Our Ref: SDNP/21/04789/ADJAUT
Contact Officer: Nat Belderson

Neighbouring Authority Consultation

Proposal: Adjacent Authority Consultation - FG/163/21/PL - Development compromising marine workshop & boatyard, martial arts gym (Class E) & storage container compound (Class B8) to replace former glasshouses. This site is a Departure from the Development Plan & is in CIL Zone 3 (Zero Rated) as other development.

Address: The Chalet , Littlehampton Road , Ferring , BN12 6PG

SITE PLAN 1:500 @ A3

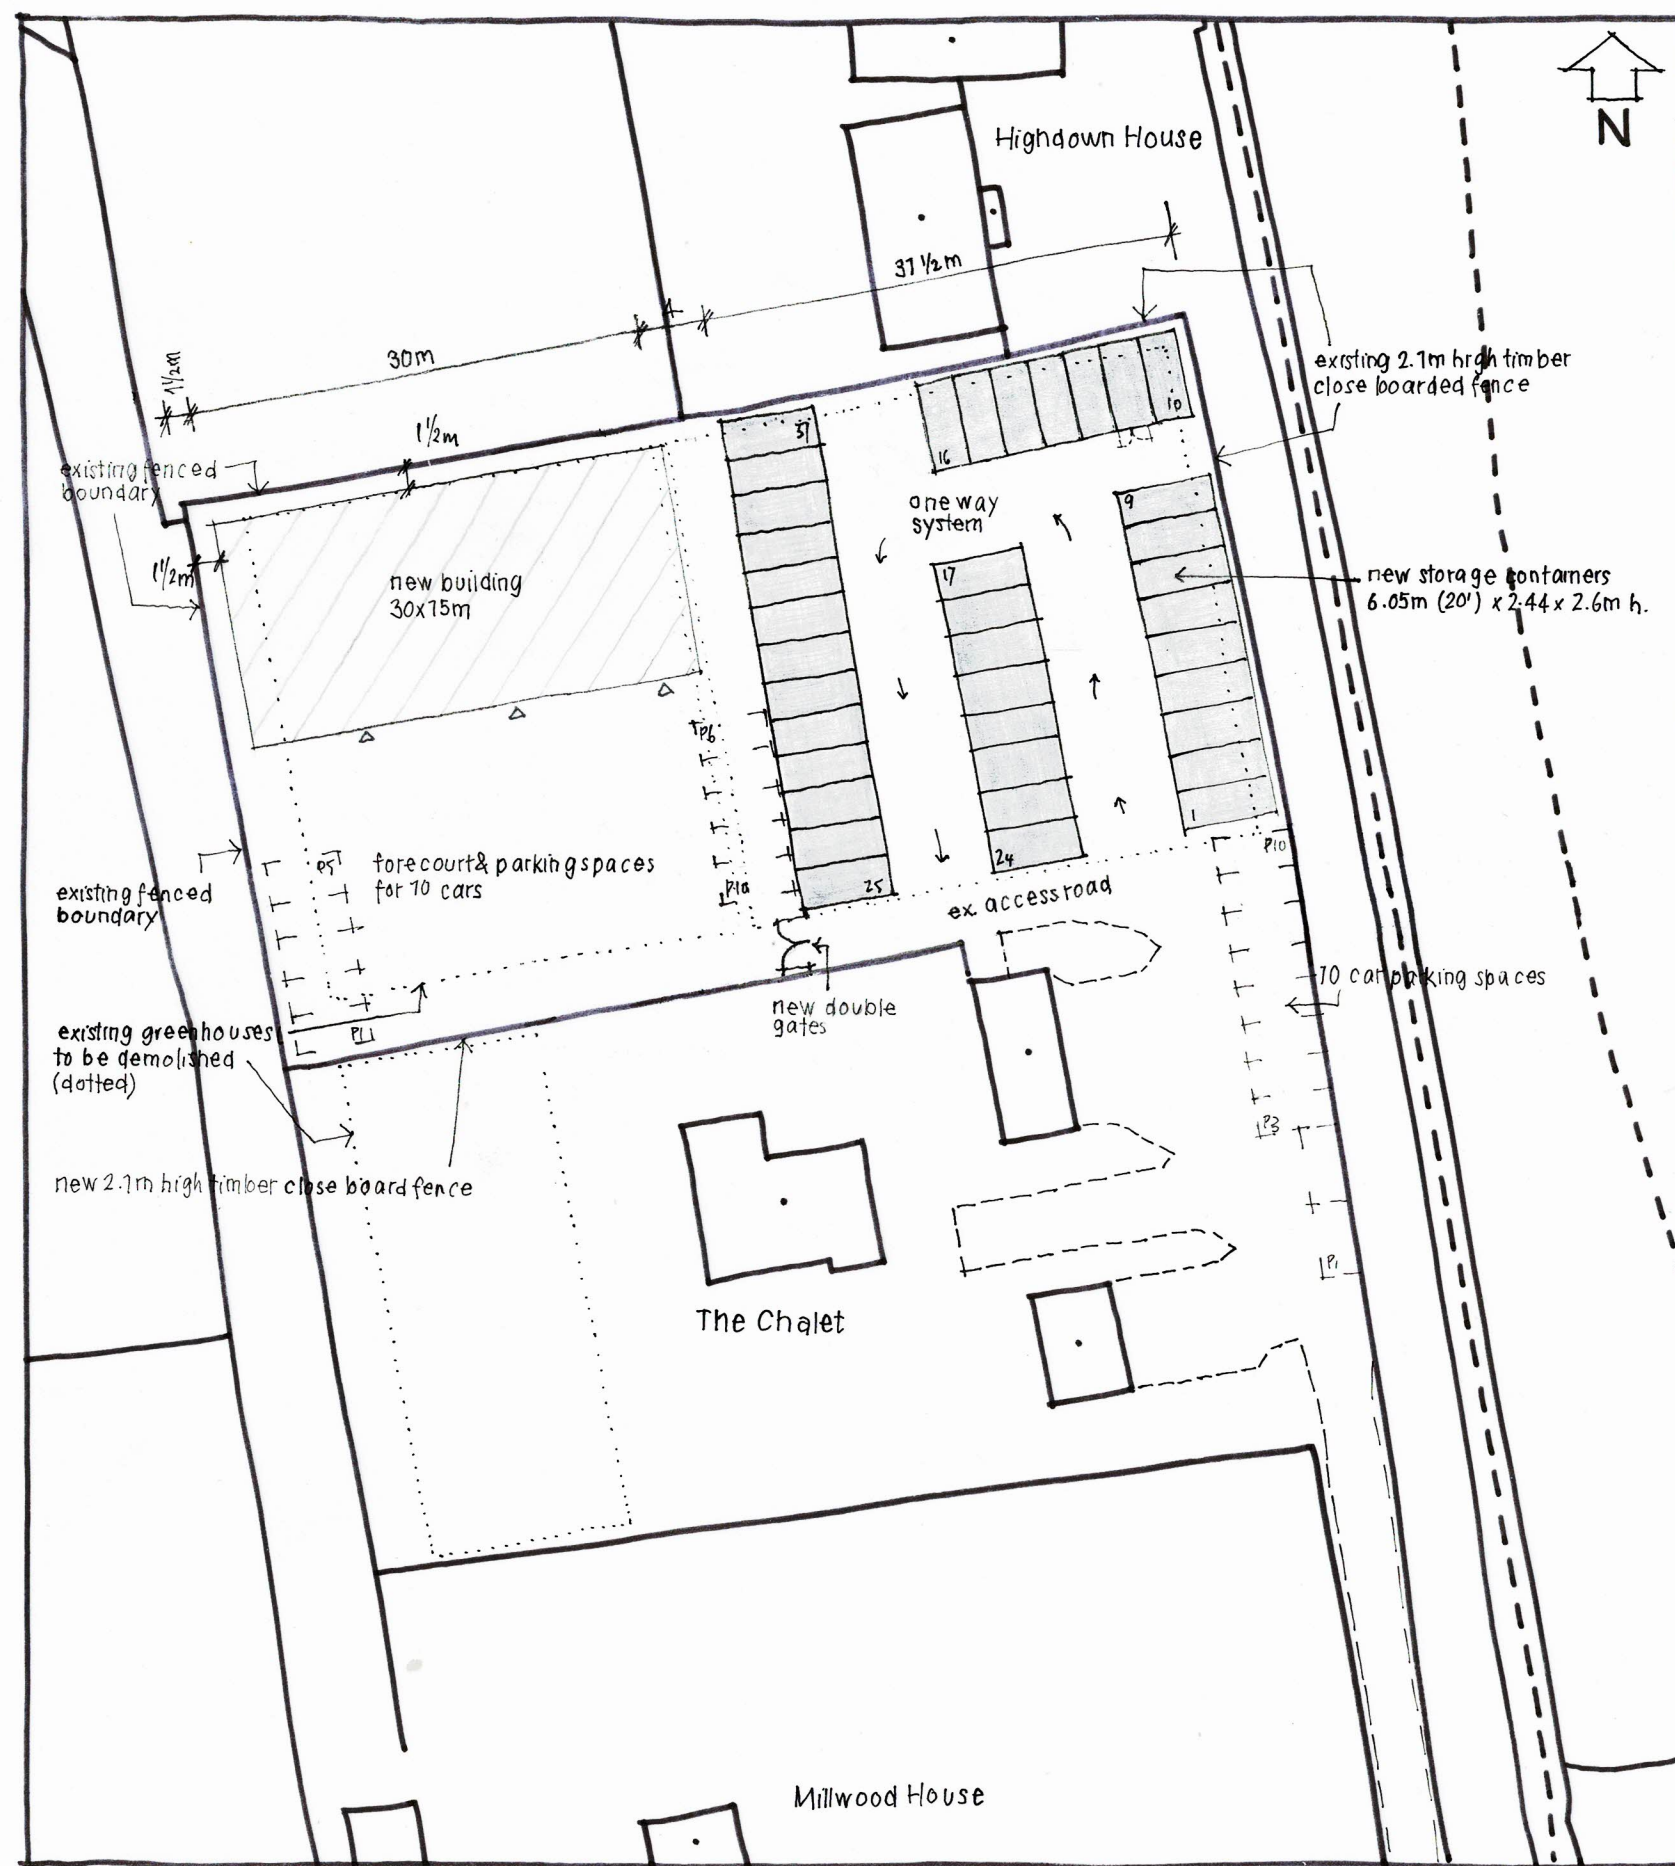
The proposal would add to the creeping industrialisation of the land along the foot of Highdown Hill and within the setting of the South Downs National Park. With this in mind, a continued agricultural or horticultural use of the land would be preferable in order to retain a degree of urban-rural transition to the north of the A259. However, if the LPA considers the principle acceptable, then it may be appropriate to seek native planting to soften the appearance of the site - particularly the eastern and western borders.
